REPORT UPDATE

Application No: BR/180/24/PL

REF NO: BR/180/24/PL

PROPOSAL: Change of use from 8 bedroom House in Multiple Occupation (HMO) to 11 bedroom HMO. This application is in CIL zone 4 and is CIL liable.

Drg. No. PG.9011 · 24 · 02 Rev. F

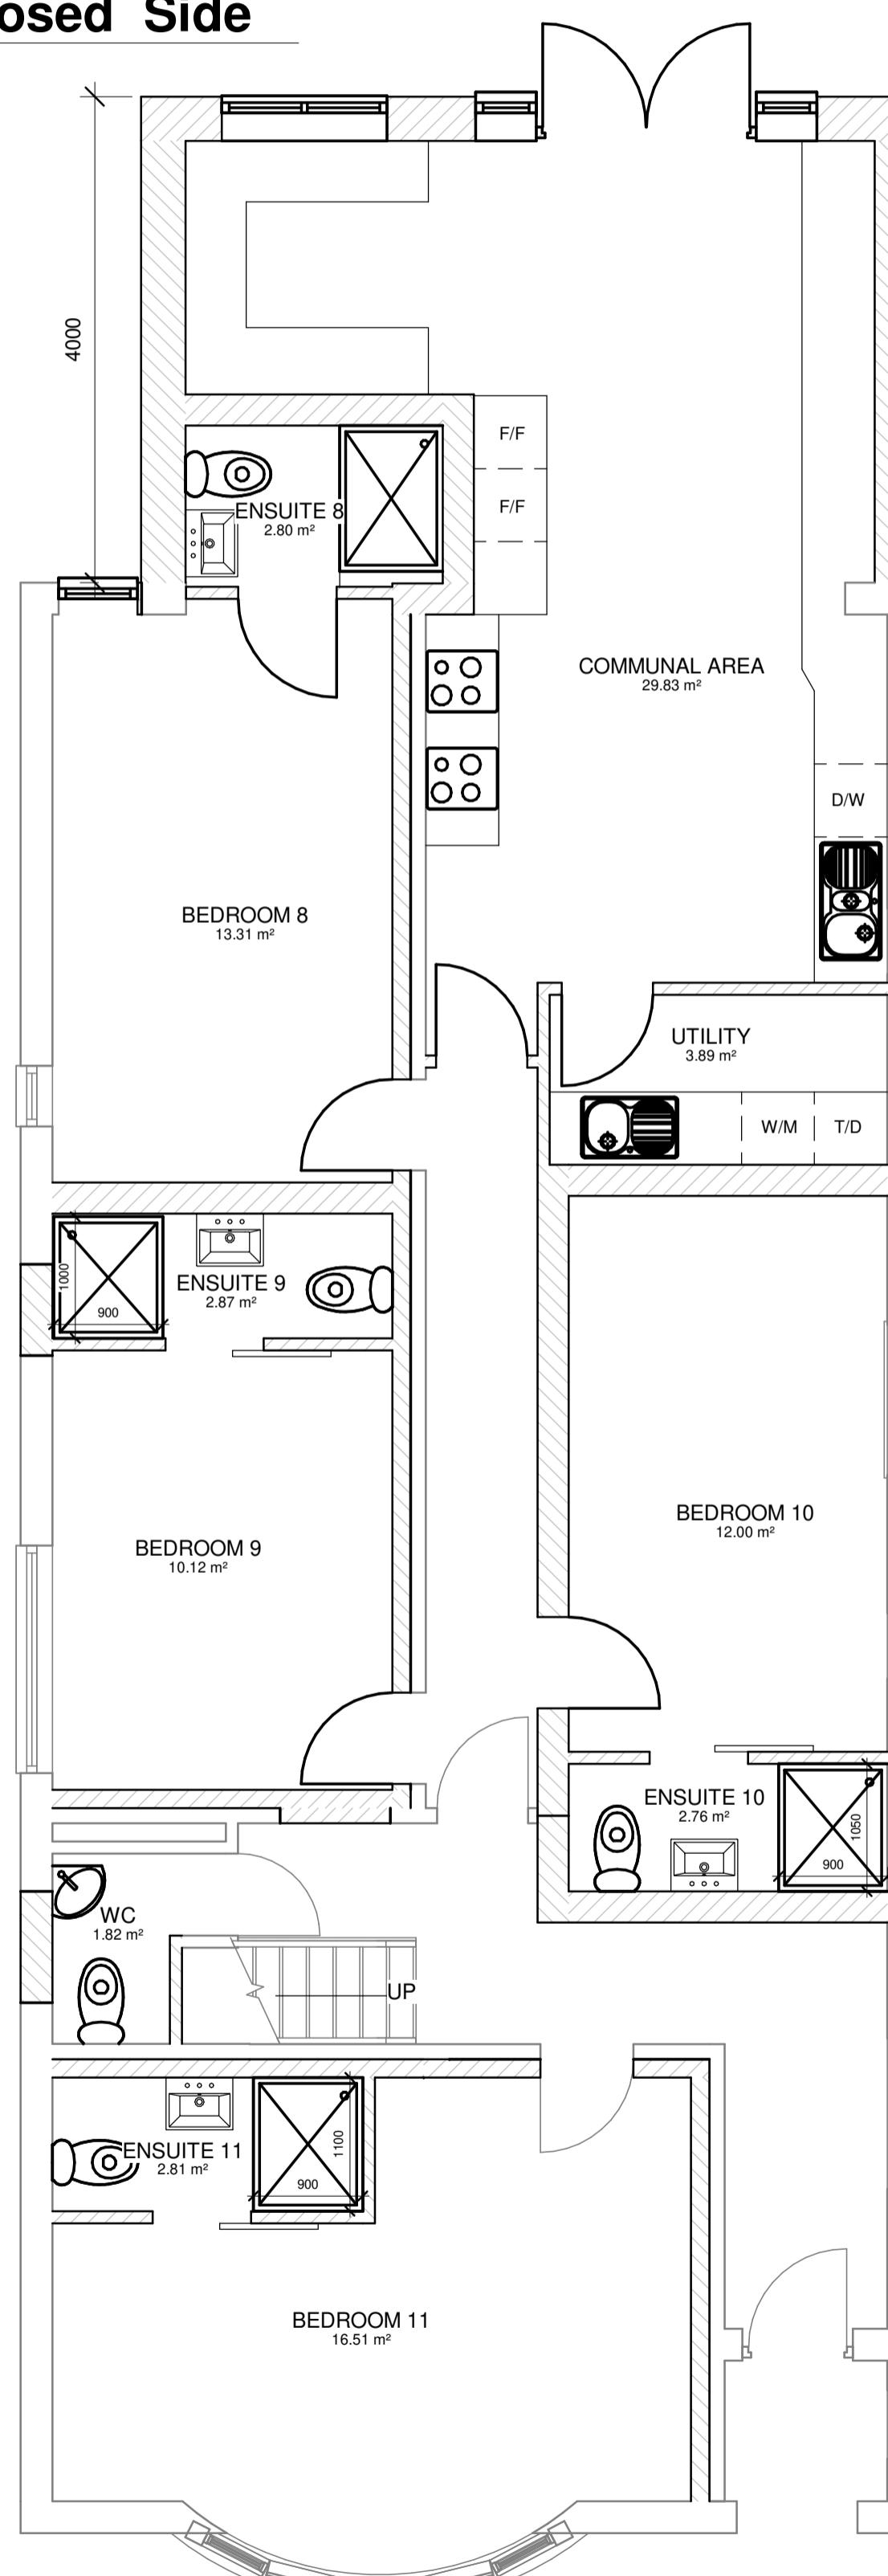
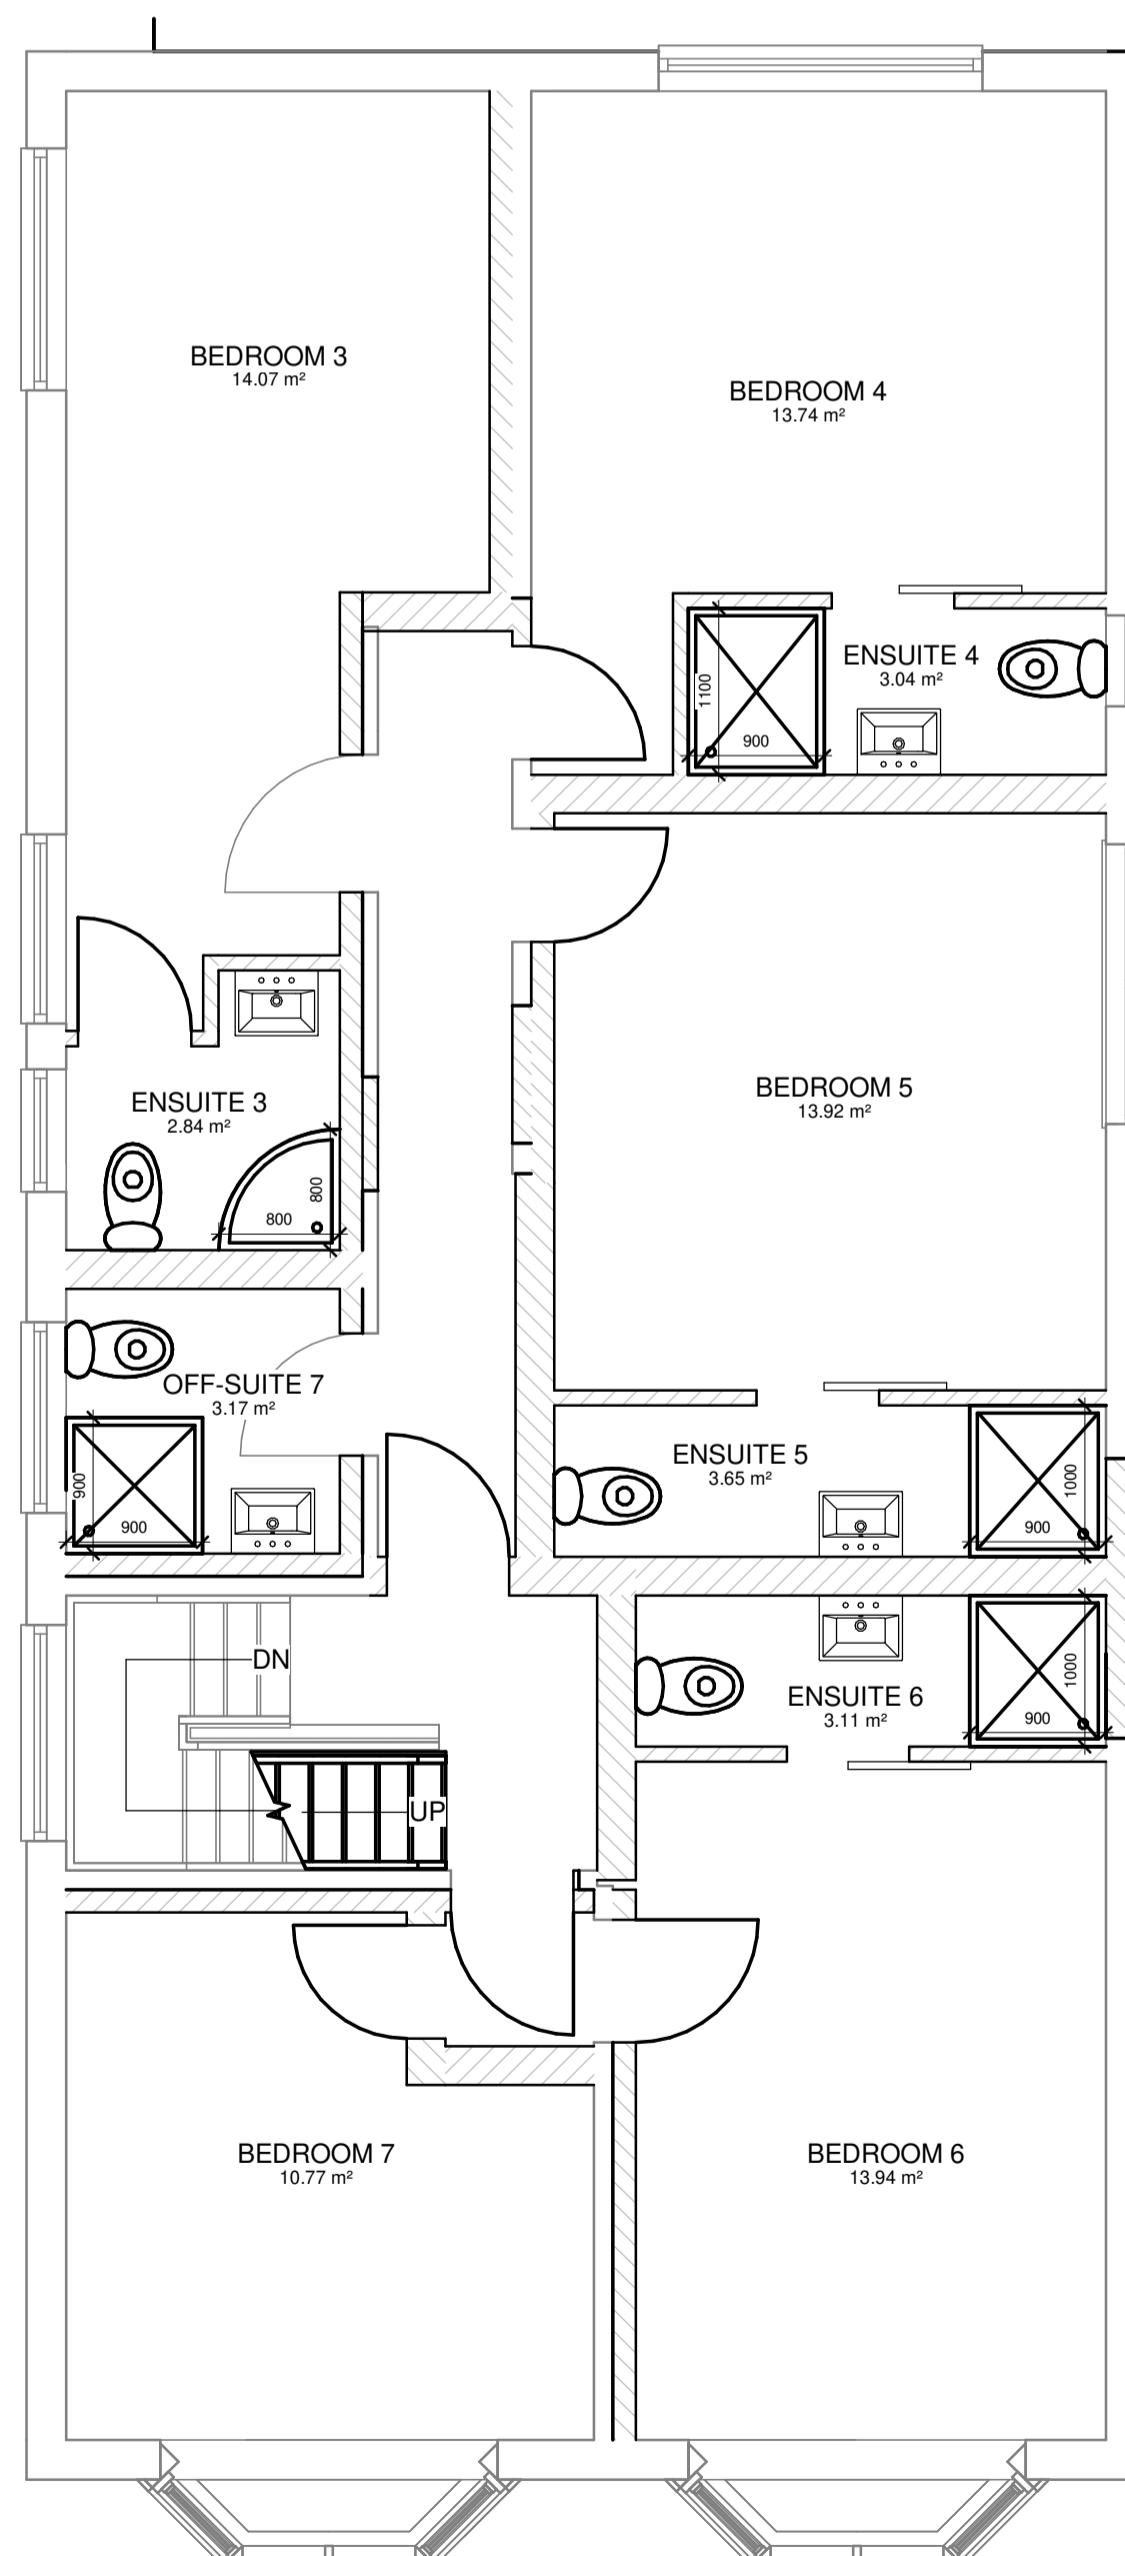
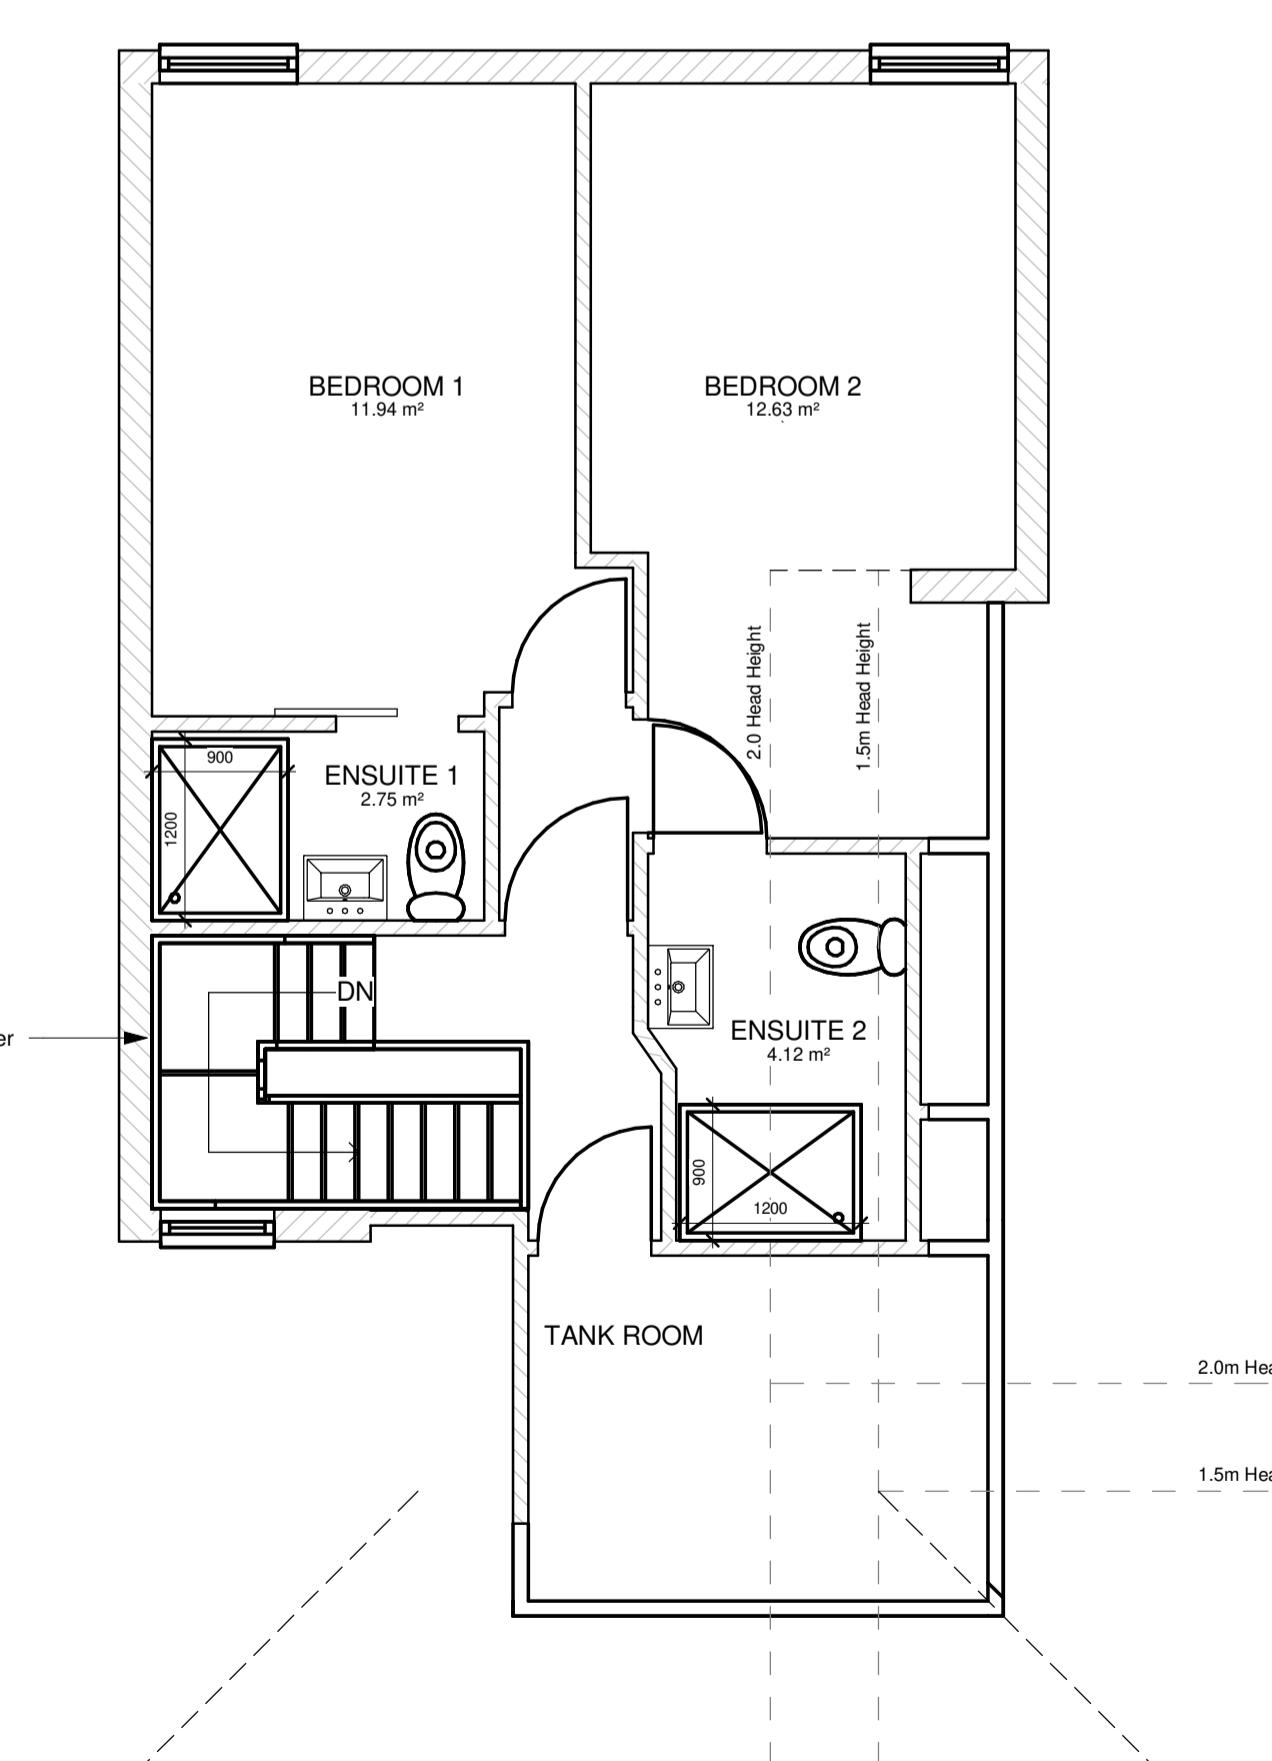
Proposed Plan PG.9022.24.02 has been updated from Revision E to F. This is due to an omission of a door to bedroom 6, which has been added.

There has also been a small change to the proposed plan which has not been mentioned within the report. In order to address concerns raised by ADC Private Sector Housing and Public Health in regard to bathroom sizes, the doors to all en-suites (bar bedroom 2) have been replaced with sliding doors, to increase the usability of the bathroom space. Attention is also drawn to the Proposed Site Plan, which details 1 no. Electric Bike Charger, which has not been mentioned in the report, but increases alternative transport options for occupiers.

Recommendation remains unchanged. Condition 2 has been updated to include the correct plan revision.
